**COMMENT ON THE PROPOSED WOOLGOOLGA TO BALLINA UPGRADE PROJECT.**

FLOODPLAIN /FLOODWATER HOLDING AREA, FERRY PARK, EASTERN SIDE OF PACIFIC HIGHWAY.  
MACLEAN.

Application Number. SSI-4963.

Figure 17-5: Tyndale to Maclean – directly affected agricultural land

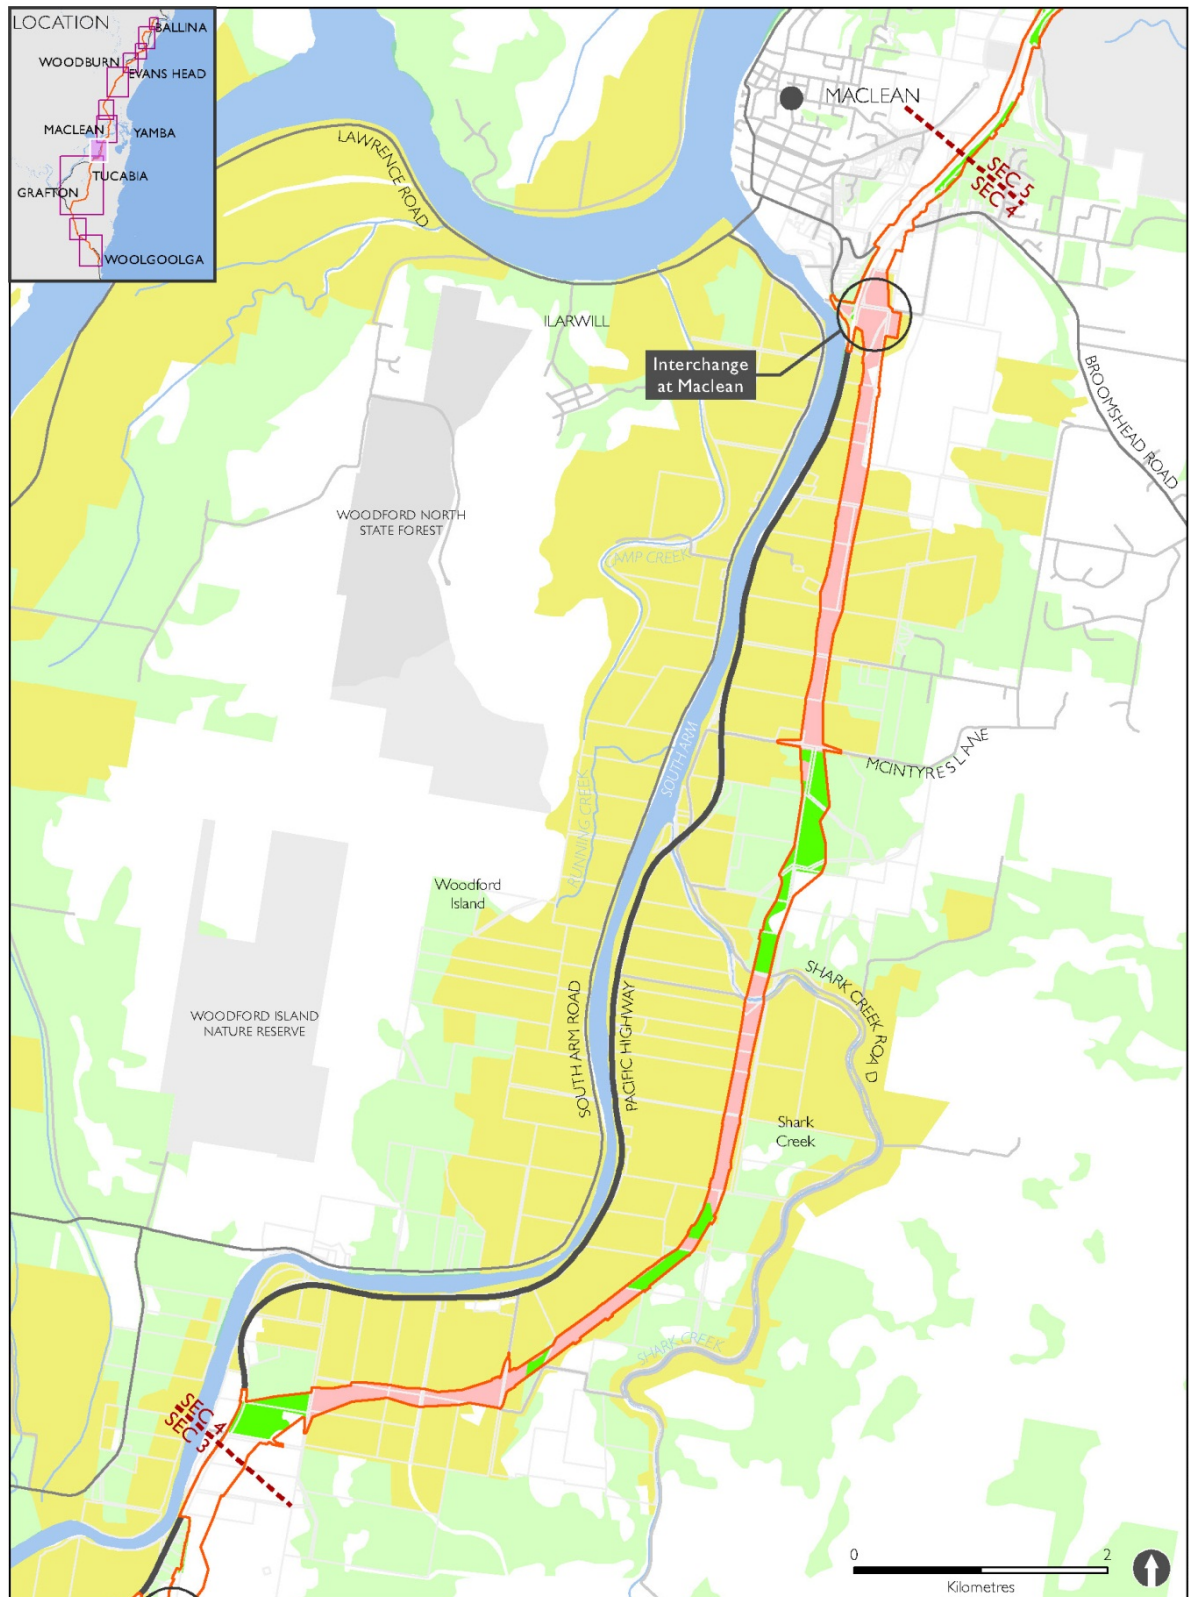
I DO NOT SUPPORT THE PRESENT CONSTRUCTION LINE AND FORMATION OF DUMBELLS IN THE FLOODPLAIN AND FLOODWATER HOLDING AREA IN THE FLOODPLAIN DIRECTLY EAST OF FERRY PARK AND EXTENDING SOUTH TO McINTYRE'S LANE.

This is a submission concerning the potential damming by partial filling of the flood plain and flood water holding area immediately east of the existing Pacific Highway at Ferry Park, Maclean and south to McIntyre's Lane.

**The Dumbbells** at the Ferry Park, Maclean Interchange are planned to be in what would be the deepest part of this flood holding area with the proposed highway construction following a line approximately through the center of the deeper section, due south to McIntyre's Lane. I am guessing at the depth of water held where the Dumbbells are to be constructed as water is still lying there but it must be around 4 meters, this depth slowly decreasing to the height of one year old cane at McIntyre's Lane, the most southern end.
